CITY OF PORTLAND, MAINE

HISTORIC PRESERVATION BOARD

October 27, 2014

Re: Request for new window opening on east elevation; 79 Commercial Street

2 ELEVATION
1/2" = 1'-0"

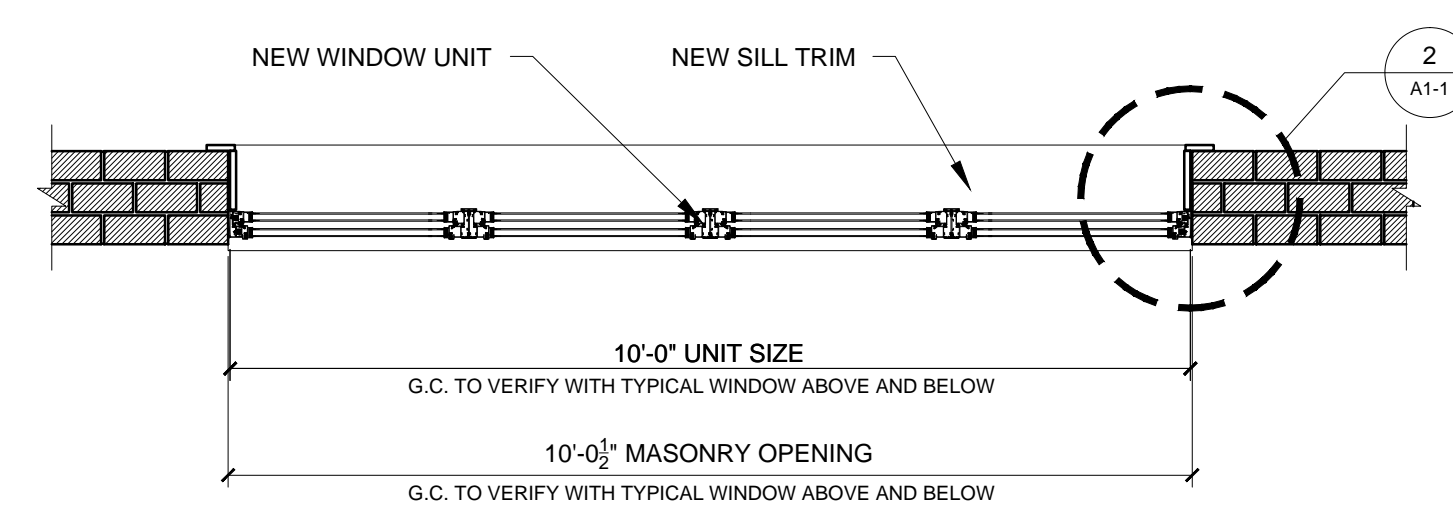
- The size and placement of the new opening to be based on “Option 2”, with the head of the new opening aligned with other window heads at this floor level and the sill raised slightly.
- Windows to be mulled, as shown in “Option 1”.
- Material and finish of new window to match existing
- Applied graphics to be applied to exterior of glazing only (not on the frames).
- The graphics shall be assessed upon installation and reassessed in three years to ensure a good color match with surrounding painted wall sign.
